Outline application for 1 no dwellinghouse and associated works.
Land south of 34 Downview Close Yapton

The Planning Committee of Yapton Parish Council has considered this application and the Parish Council wishes to register an objection on the following grounds:- ☐

LOCATION PLAN 1:1250

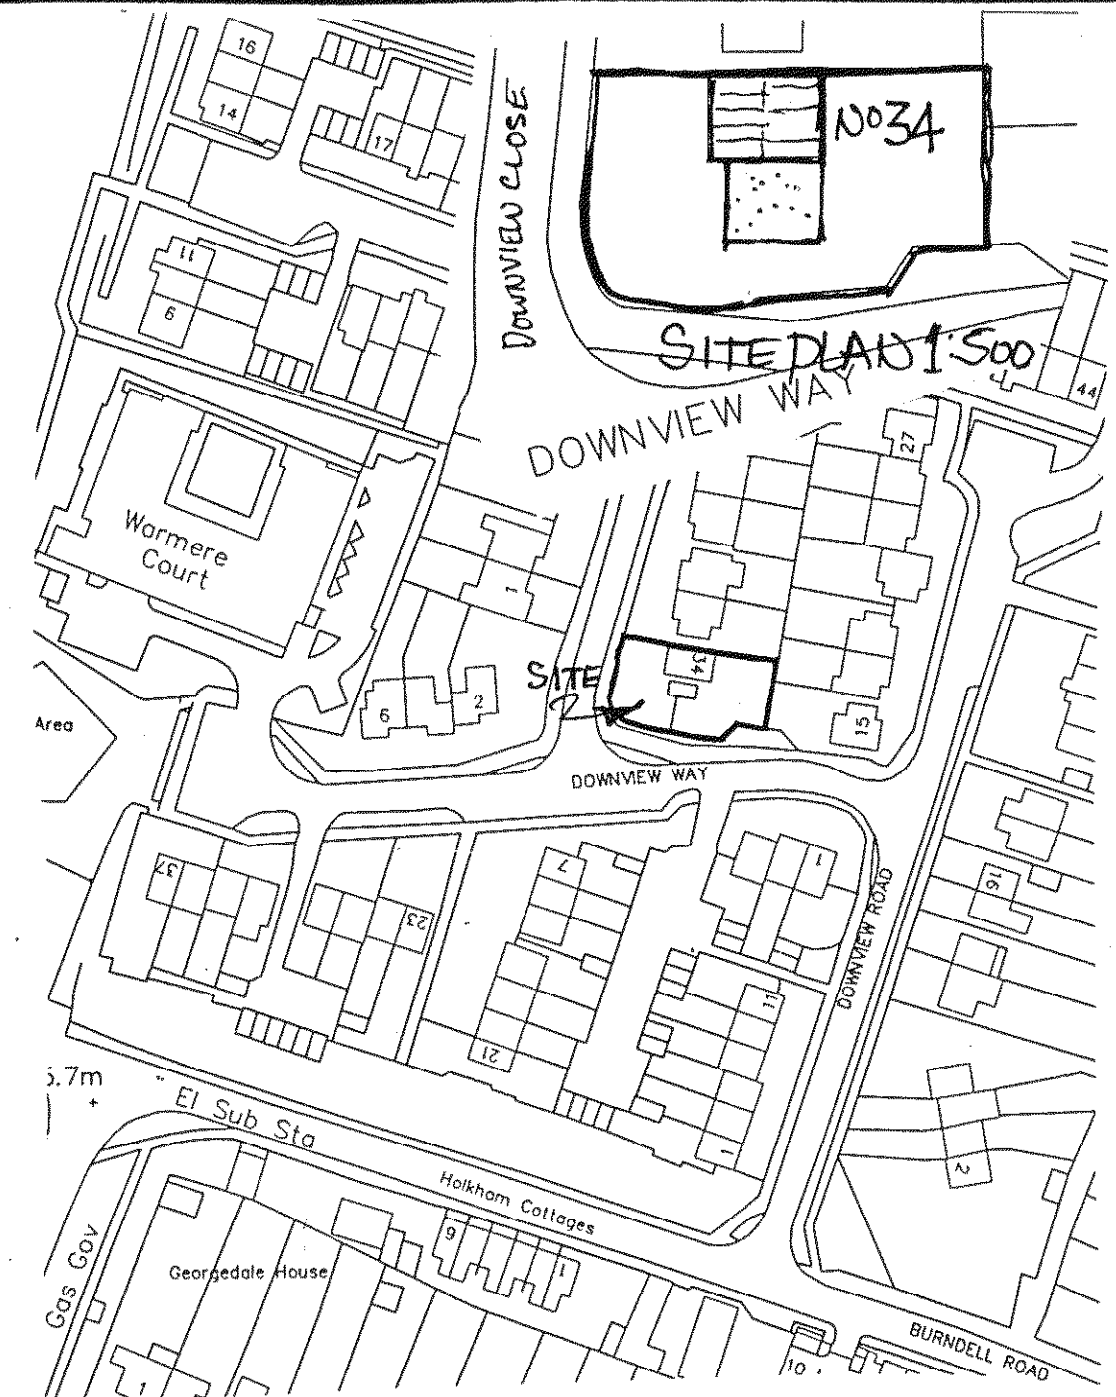
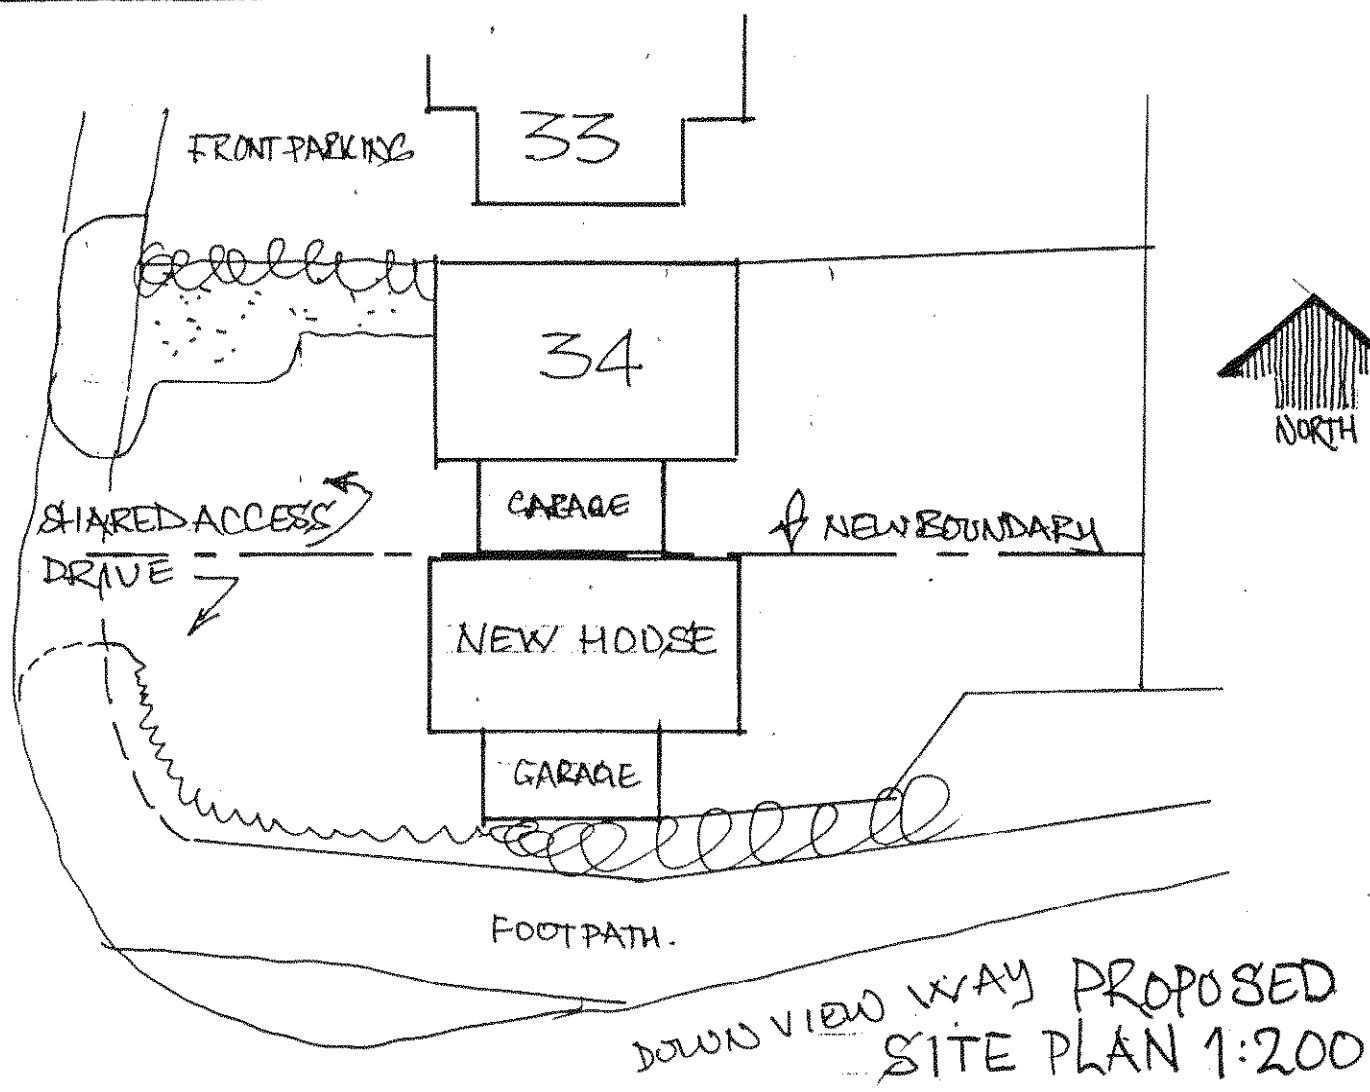
1) The construction of another property within the curtilage of 34 Downview Close in such a small area of land represents an overdevelopment. ☐

5) The proposed property would have no garden area at the front; the plans indicate the whole area would be used to provide hard standing and access to the garage. ☐
